Manorwood Homes

Lince Lane,
Kirtlington

Technical Note

- 3.1 An independent Stage 1 RSA, completed in accordance with GG119, was commissioned on the site access layout (TPA drawing 2207-015 PL01(D) – Proposed Site Access) in October 2023. The Stage 1 RSA along with the Designer’s Response Report are contained in **Appendix B**.

SCALE: NTS	DATE: 12.10.23	DRAWN: TW	CHECKED: DF	APPROVED: DF
JOB NO: 2207-015		DRAWING NO: VS02		REVISION:

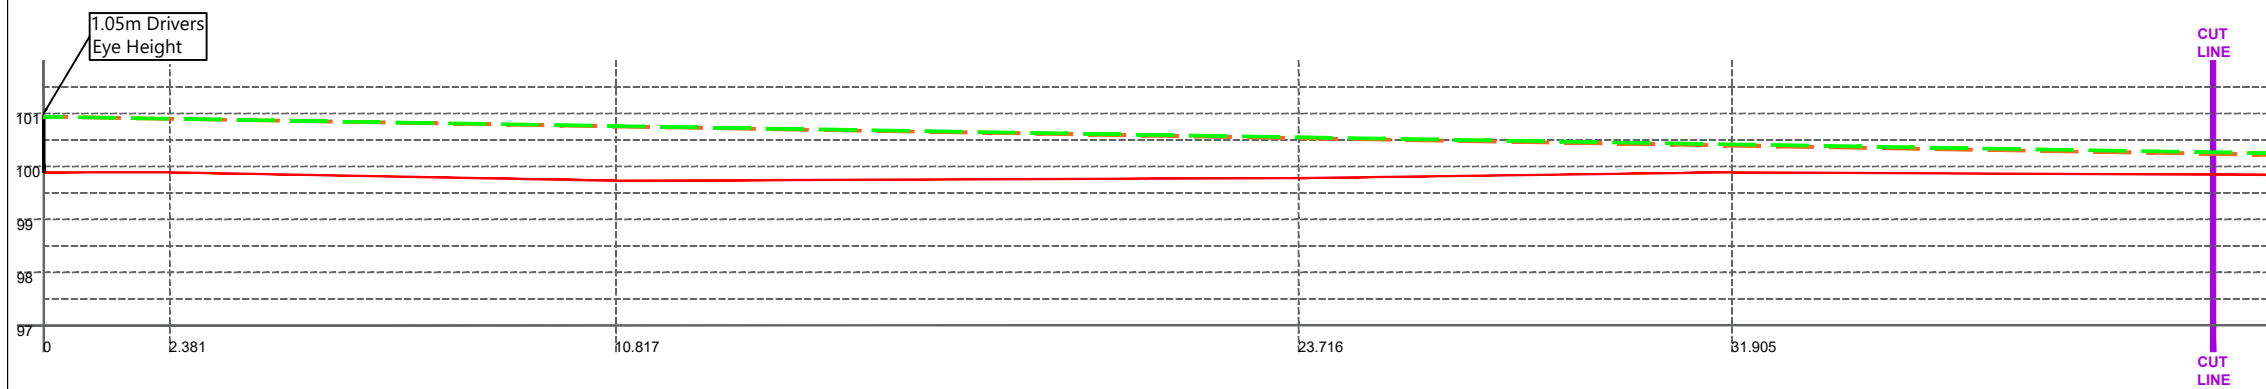
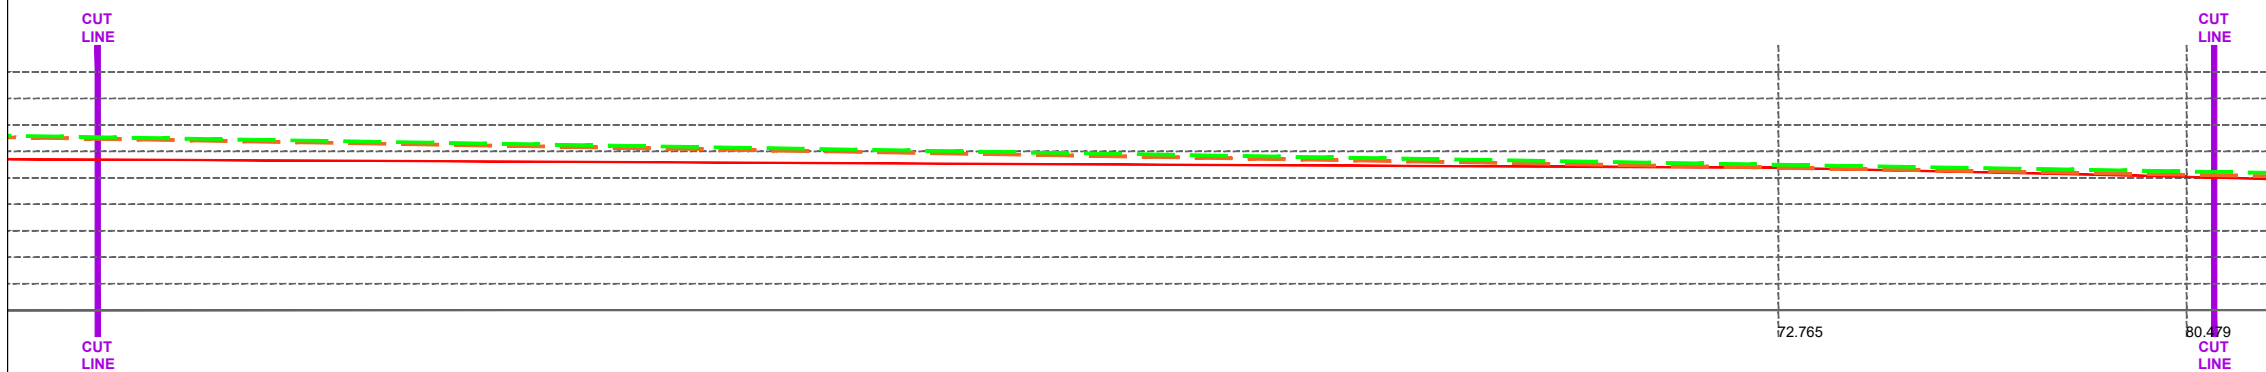
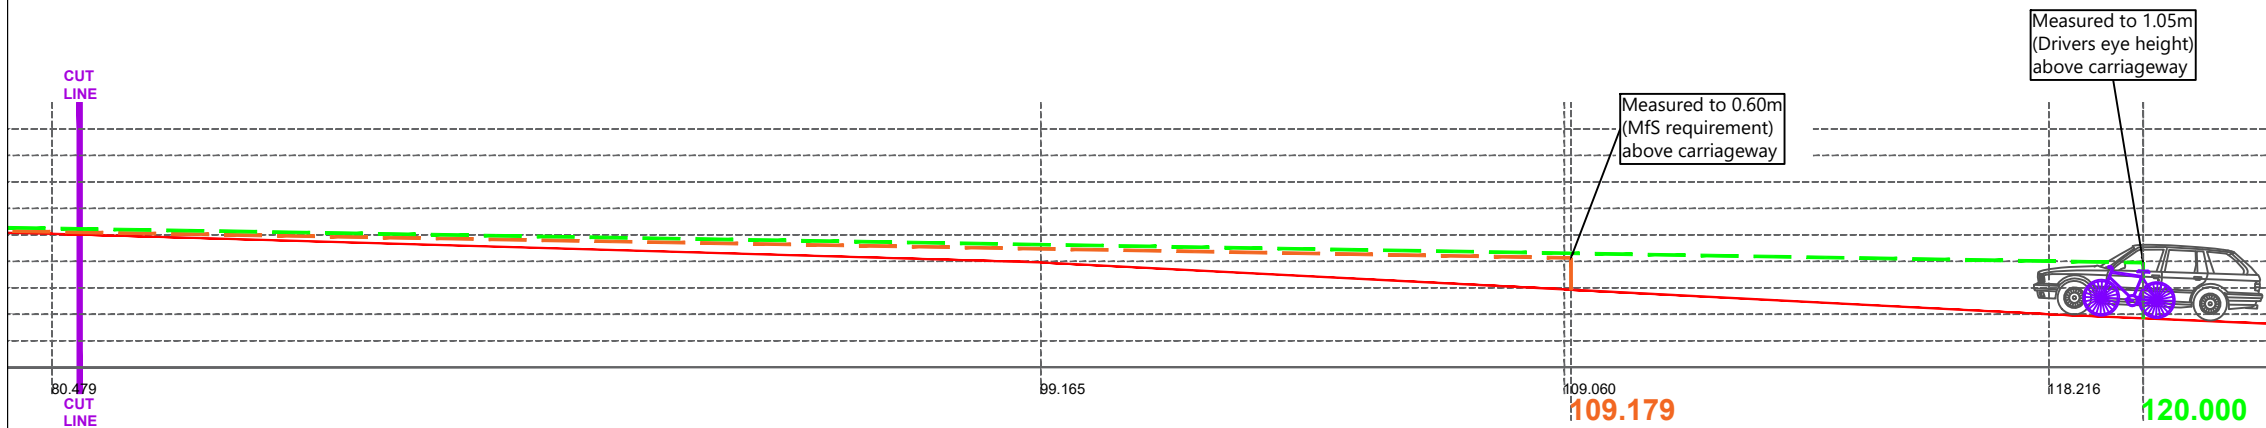
“Provision of adequate forward visibility of opposing vehicles for motorists waiting to turn right into access.”

- 3.3 As set out in the Designer’s Response Report (**Appendix B**) appropriate forward visibility for drivers waiting to turn right into the site can be provided with drivers being able to see approaching vehicles at a distance of 56m.

- 3.4 The provision of 56m visibility splays is suitable for vehicle speeds of up to 37mph when using Manual for Streets³ and is considered to be appropriate given that the observed 85th percentile northbound vehicle speeds were 33mph. Therefore, the provision of a 56m forward visibility splay is in excess of those required for the observed vehicle speeds.
